TECHNICAL NOTE

Reference: P1047t02v01

Response to Submissions

New Catherine Field Public School, O'Keefe Drive, Oran Park (SSD 9477)

Figure 2 Construction vehicle Route

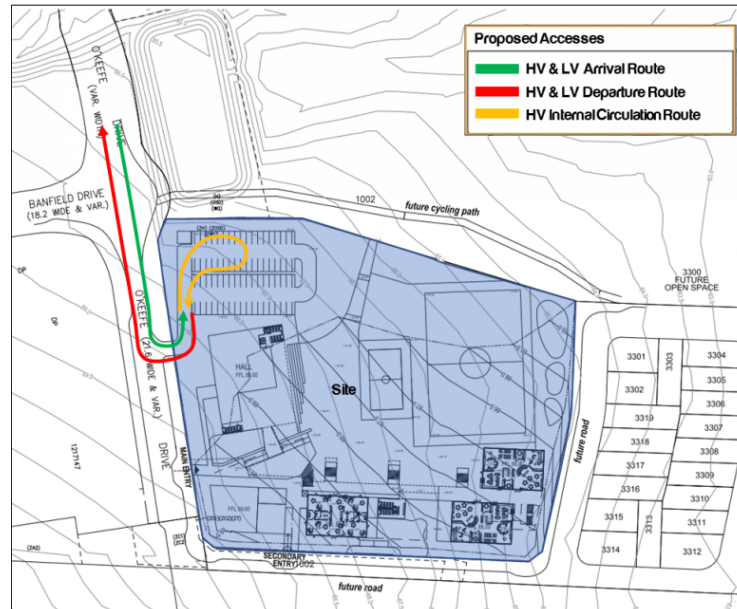
Direct access off O’Keefe Drive is not supported due the potential impact created by turning truck movements in and out of the site close to residential houses. A temporary access point should be located at the southern end of O’Keefe Drive. This will also protect the existing kerb and gutter. In addition to owner’s consent for the subject site, owner’s consent must also be provided for the relevant lot if any works or access is proposed on or from adjoining lots (rather than the road reserve).

This comment appears to be offering conflicting advice—access off O’Keefe Drive is not supported, locate temporary access at southern end of O’Keefe Drive.

O’Keefe Drive is 12.5 metres wide at the northern and southern ends adjacent to the site and the southern end has been identified as an emergency access. Accordingly, the access location shown in Figure 1 are deemed appropriate and acceptable.
